Consultation Response from KC Conservation and Design		
2018/94180 Stalley Royd Farm, Stalley Royd Lane, Jackson Bridge, Holmfirth, HD9 7HX		
Listed Building Consent for change of use of barn to a dwellinghouse, formation of new access, and for a new detached double garage for adjacent property		
Date Responded: 20/02/19	Responding Officer: Craig McHugh	Responding Ref: HO 5/302
Summary The barn contributes to the significance of the grade II listed farm house and illustrates the mixed nature of farming undertaken in the past which depended on cereal crop production, animal husbandry and textile production. Its vernacular detailing complements that of the farm house. There is no objection in principle to the conversion of the building to residential use. However, the proposed alterations would result in the loss of the door and window to the outbuilding, which would be harmful, as would the insertion of so many large openings into the west elevation of the barn. Conservation and Design have concerns on heritage grounds particularly with regards to paragraph 190 of the NPPF. We should seek revised proposals that reduce the size and number of new openings. Significance of the heritage

CLIENT: MR I CONROY	
JOB TITLE: CHANGE OF USE OF AGRICULTURAL BUILDING AT STALEY ROYD FARM, JACKSON BRIDGE	
DRAWING TITLE: EXISTING PLANS and ELEVATIONS	
DRAWN: AO	DATE: NOV '18
CHECKED: JC	SCALE: 1:100 @ A1
DRAWING NUMBER:	2393 - 33

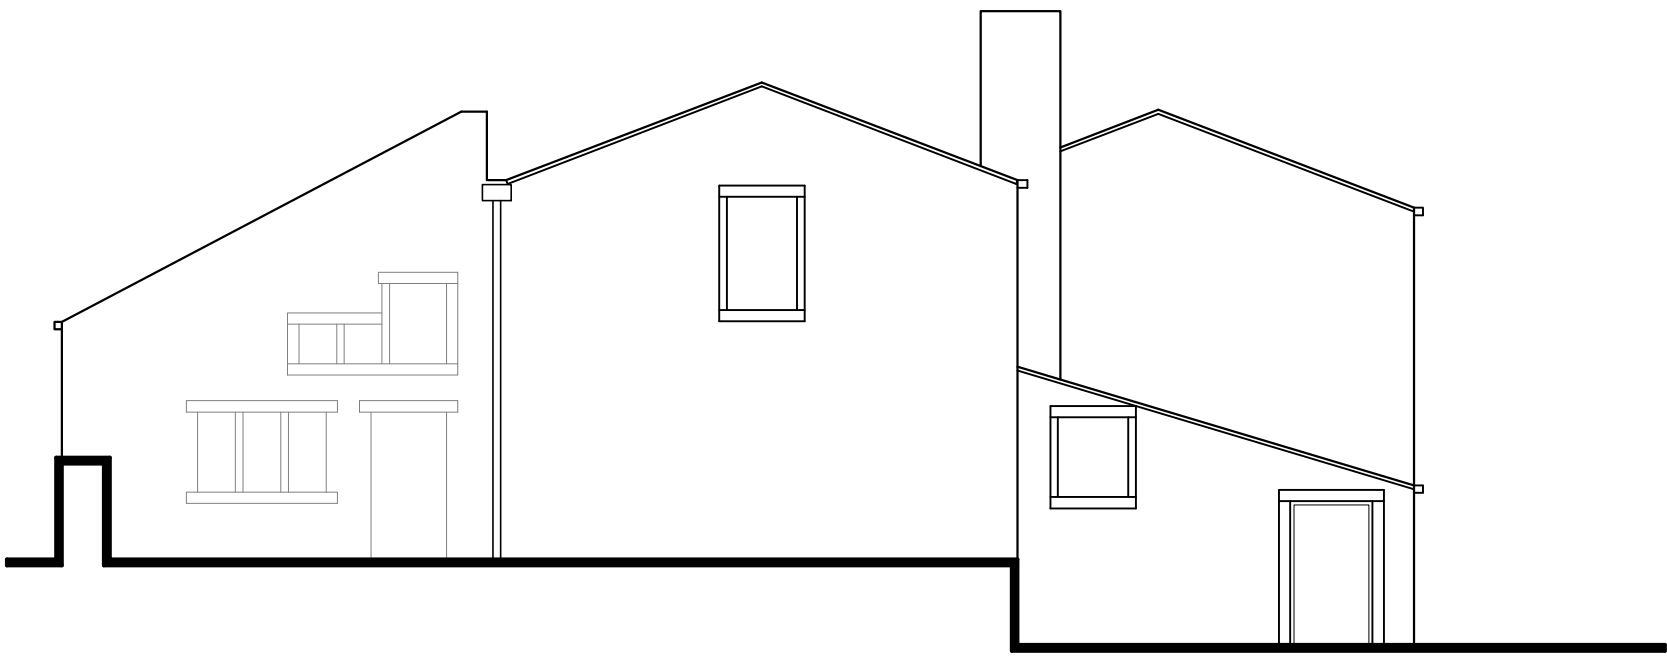
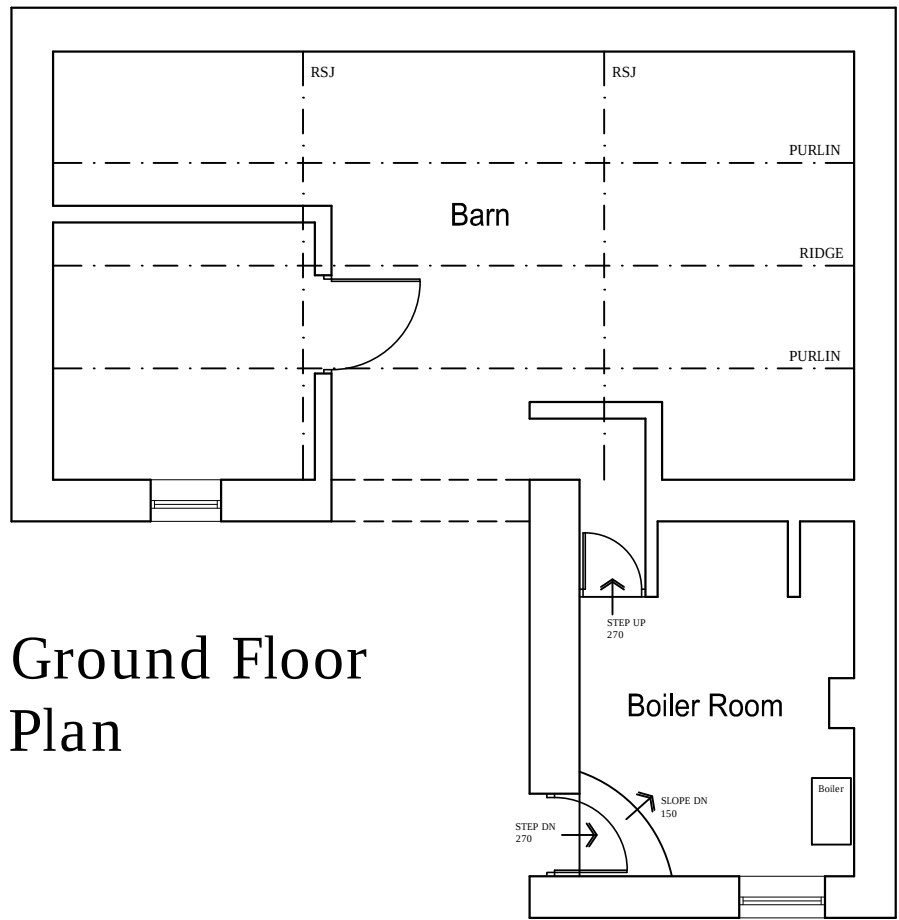
minimise any conflict between the heritage asset's conservation and any aspect of the proposal (NPPF para.190). As set out above, the loss of feature of interest and the number and size of new openings would be harmful. We should therefore seek to reduce this harm, so far as is possible.

We should seek revised proposals that reduce the size and number of new openings. New openings should be of a less domestic nature and a more agricultural character i.e. square. Use should be made of the existing gable opening, which appears to have no function in the present layout.

The roof of the barn is modern and so could accommodate rooflights for the first floor front rooms, the windows above the outbuilding look particularly uncomfortable squashed up under the eaves.
